Rezoning Transportation Analysis

Petition Number: 2021-092

| Date | Description |
|------------|--------------------|
| 08-23-2021 | Second Review (KP) |

SHEET NUMBER
RZ-1.0

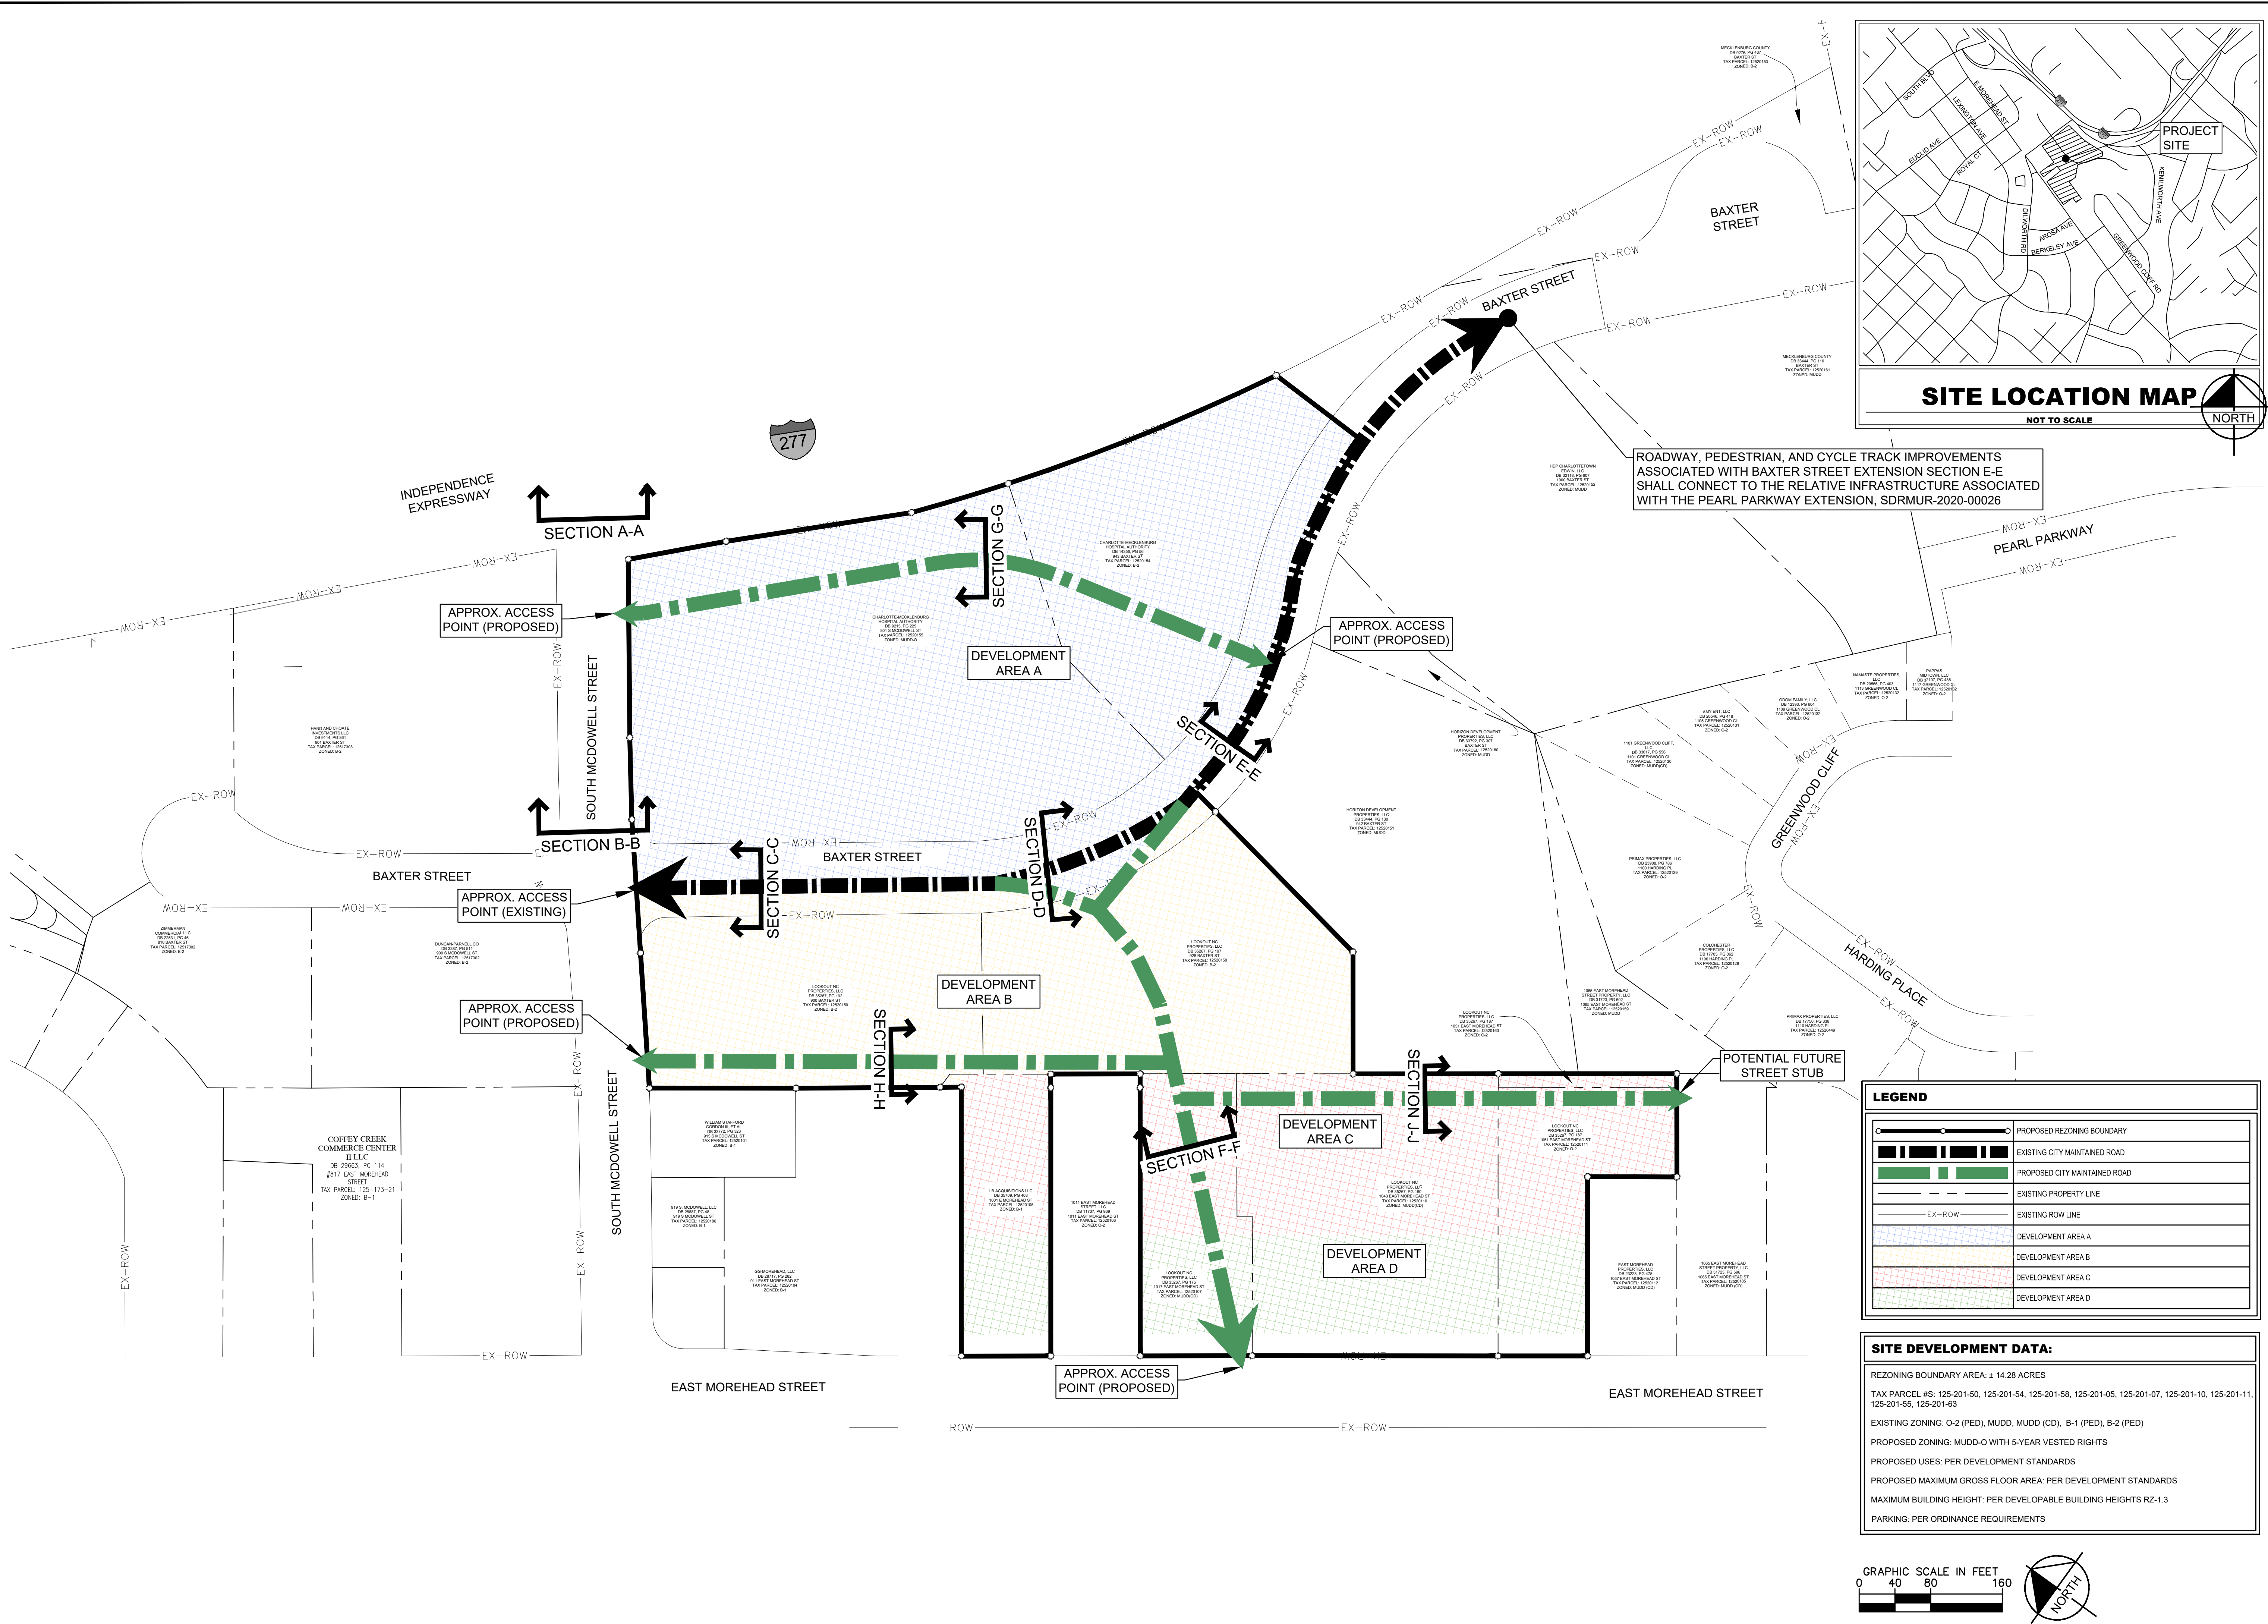
Revise each site plan sheet by appropriately labeling the numerical access points and alphabetical street designations as they are written and described under the Transportation Demand Management Plan section of the conditional notes.
